**Subject: Independent Fire Protection Review for Cumberland County Civic Center Renovations**

A review has been completed of the fire protection construction documents (CD) set, dated 21 January, 2013, which has been developed to support renovation efforts at the Cumberland County Civic Center in Portland, ME. The documents reviewed included both the fire protection demolition and design drawings, along with the design specifications for the various fire protection and life safety related systems.

SHEET TITLE: MECH. LEVEL - LIFE SAFETY PLAN - CENTER STAGE
WBRC CAD FILE: C:\Revit\Local\2013\03\032813\032813.dwg
PROJECT No. 3757.00 GRAPHIC SCALE: 1" = 1'-0"
SCALE: As indicated
PROJECT MANAGER: JRB
DRAWN BY: RAD
CHECKED BY: MEJ
SHEET No. **LSB.00**

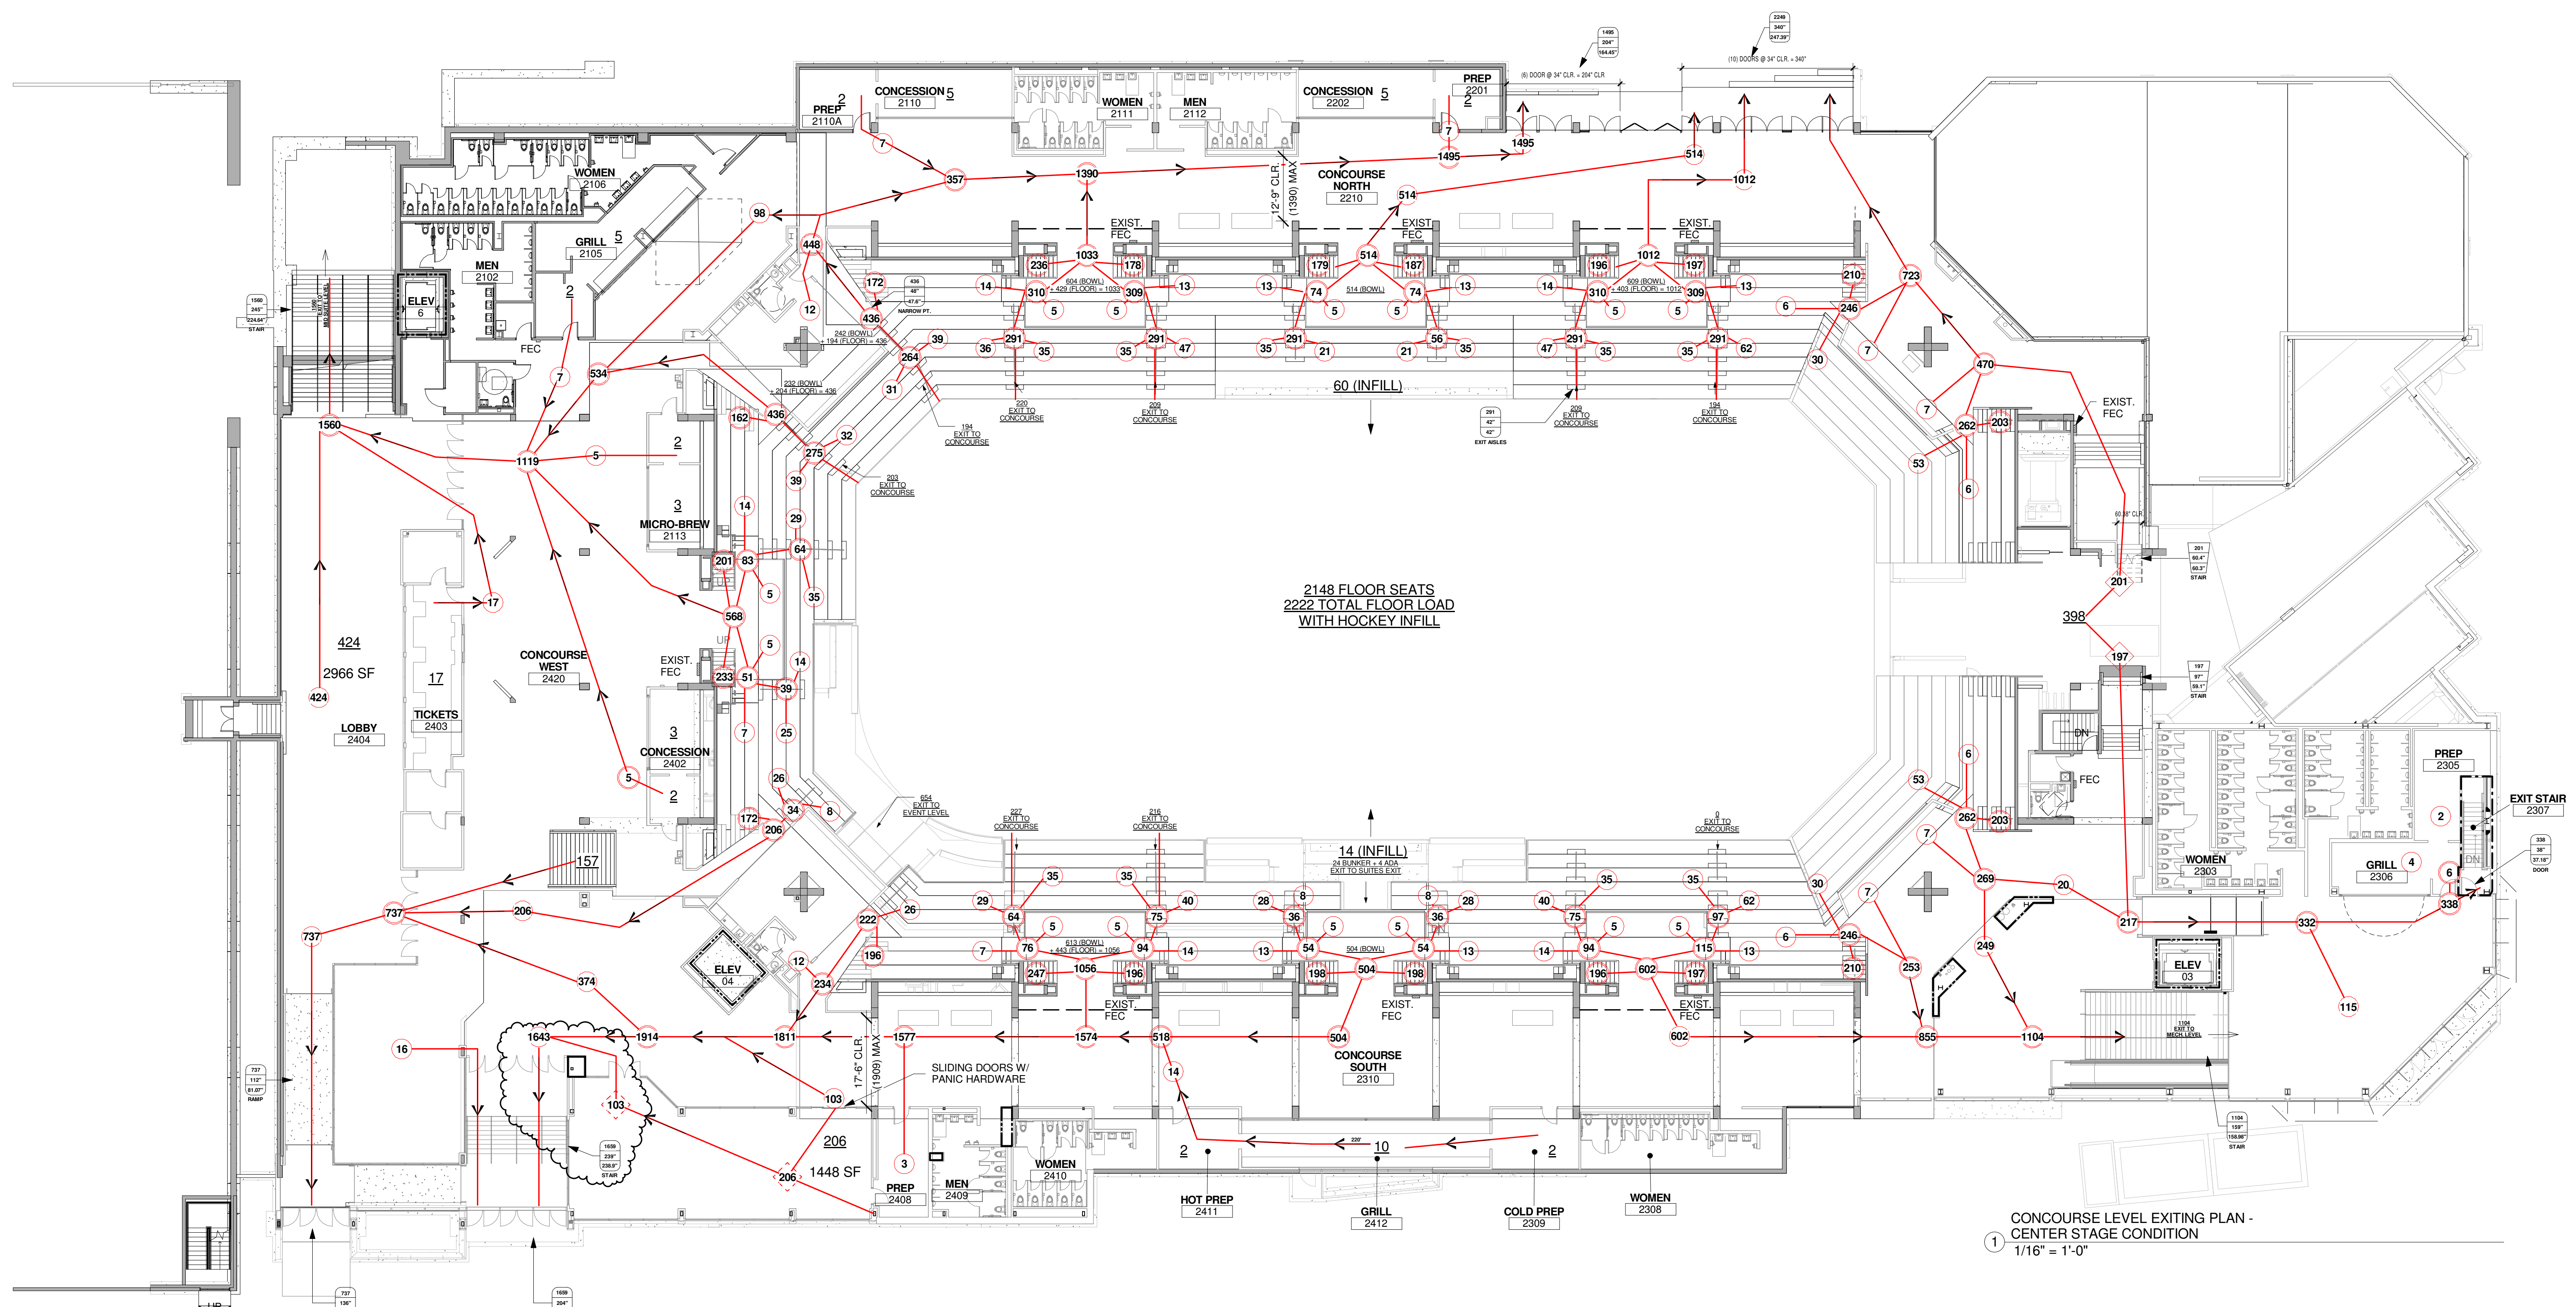
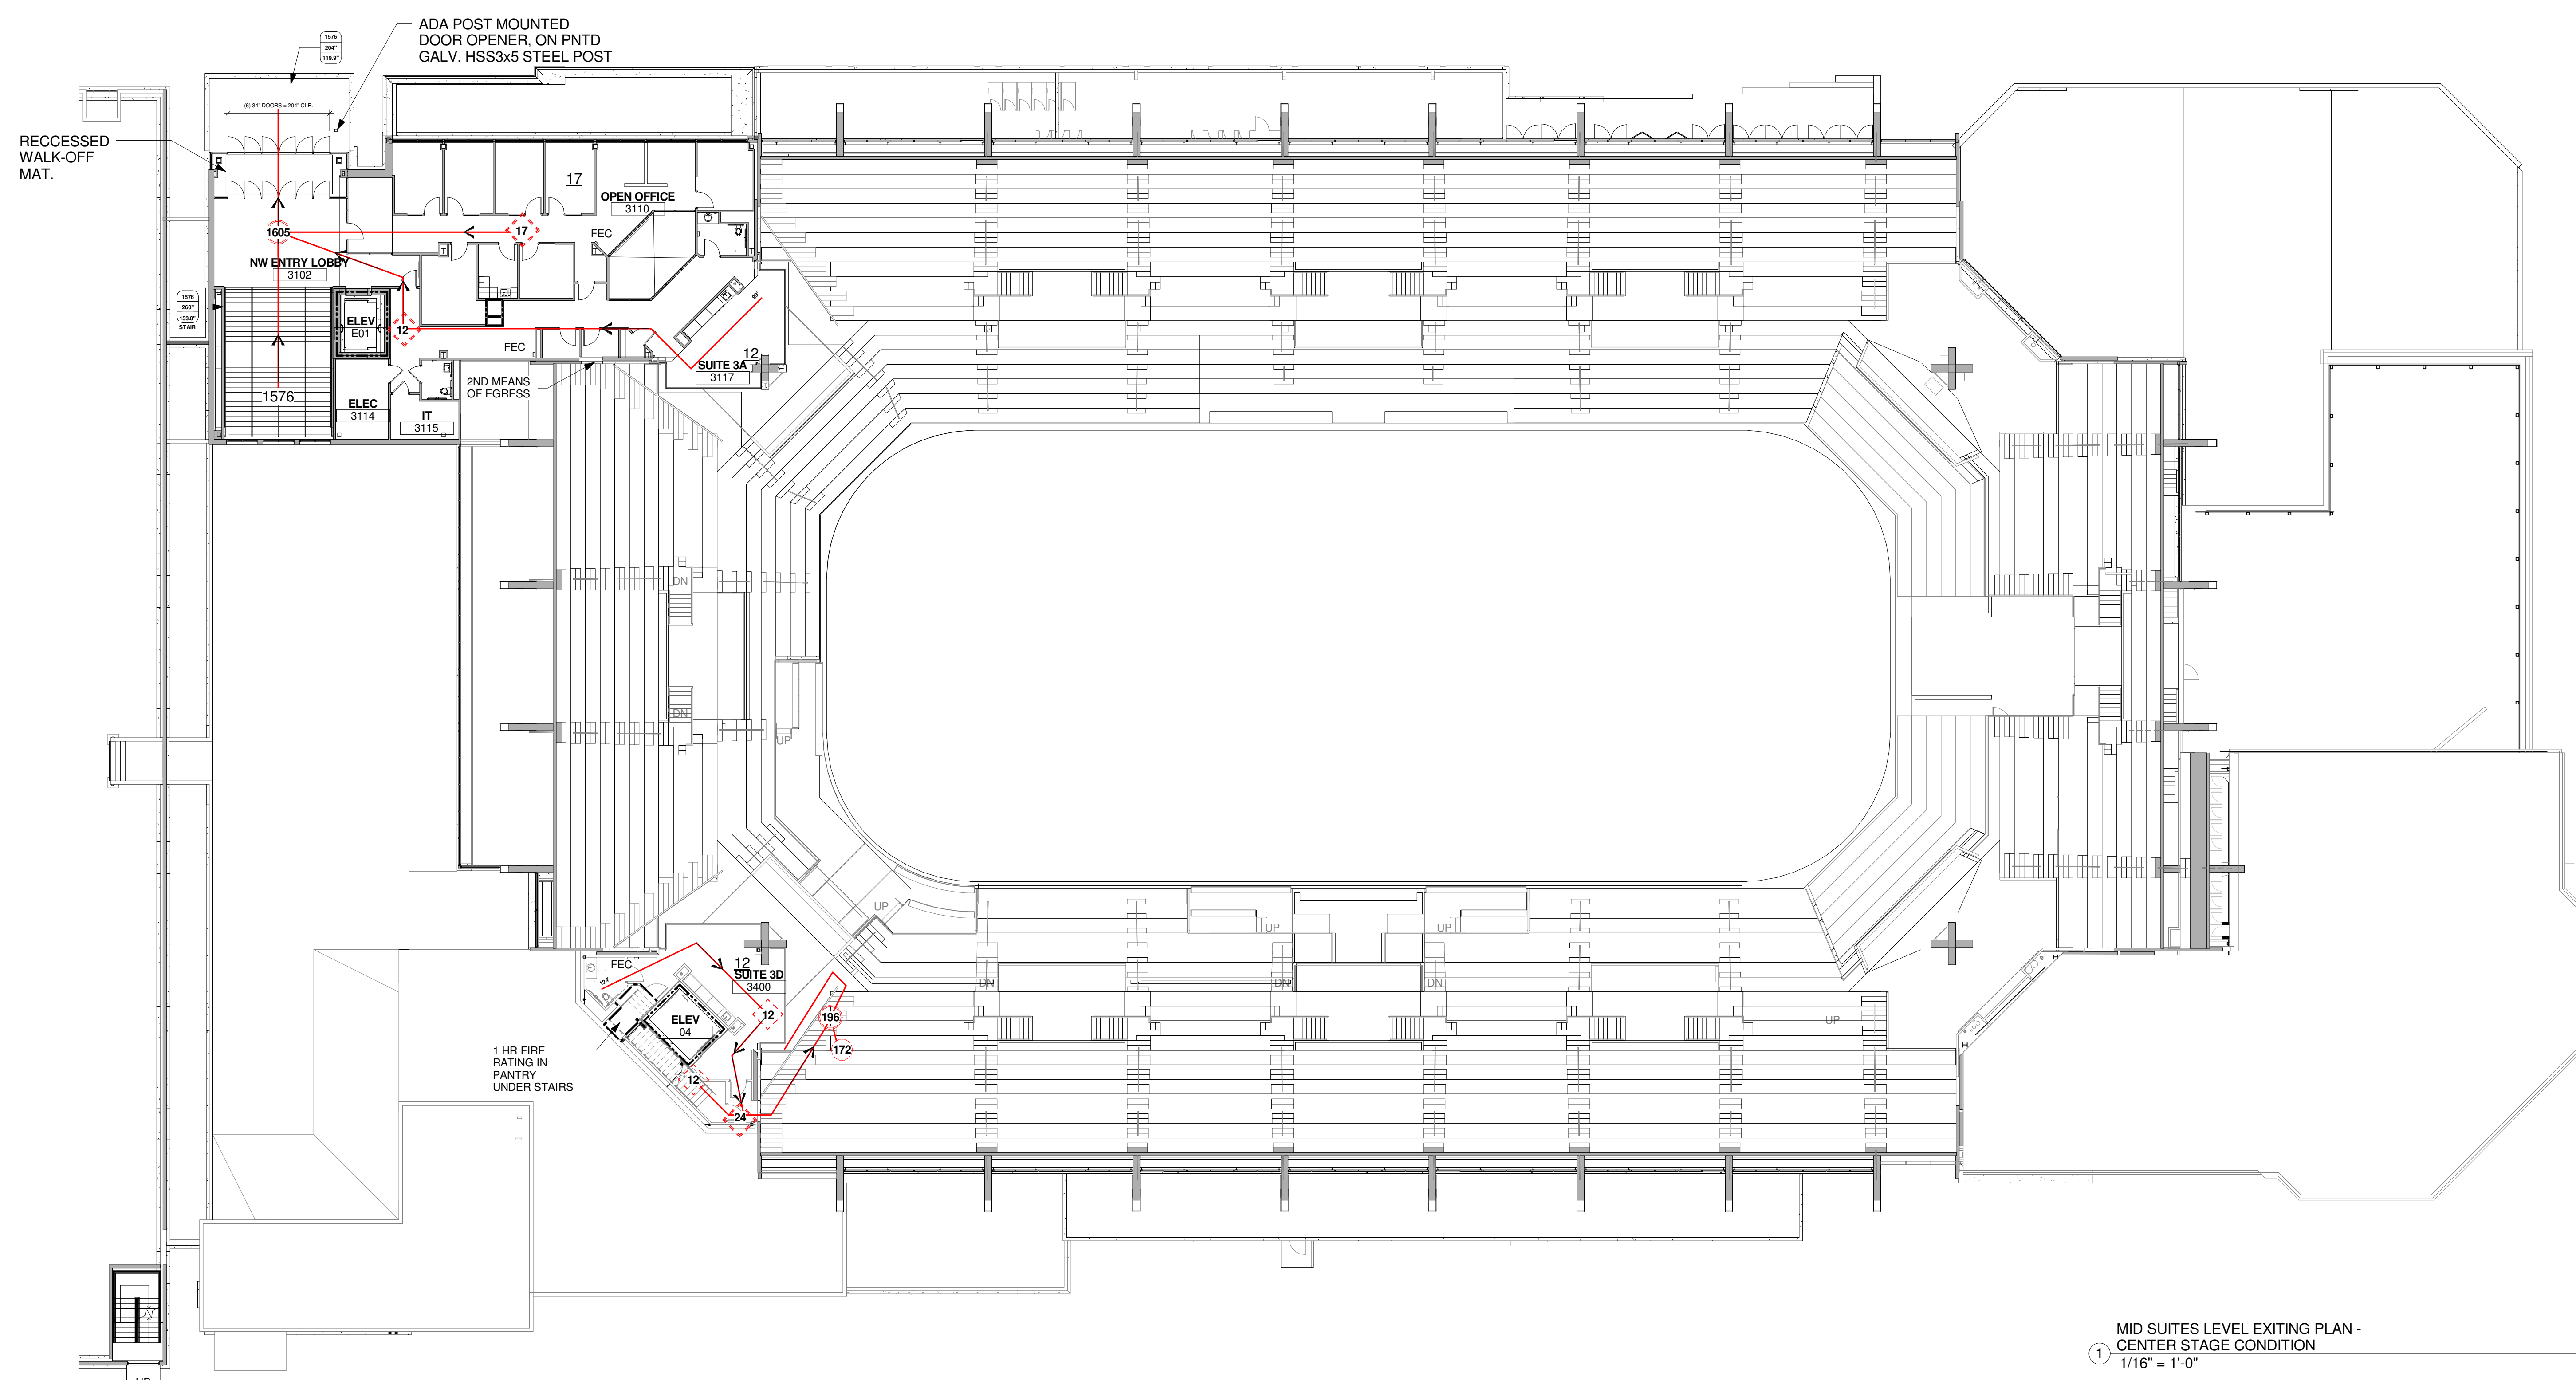
Some of the fire barrier requirements shown on the Life Safety Plans are not properly depicted and/or are not consistent with code requirements. For example, no fire rated barrier is depicted for the Fire Pump Room. These plans should be reviewed to verify that all fire rated barriers are properly depicted on the plans, to include highlighting requirements associated with floor/ceiling assemblies. It would also be recommended that all locations for the fire extinguishers be depicted on the life safety plans, such that they can be readily identified and verified as meeting code requirements.
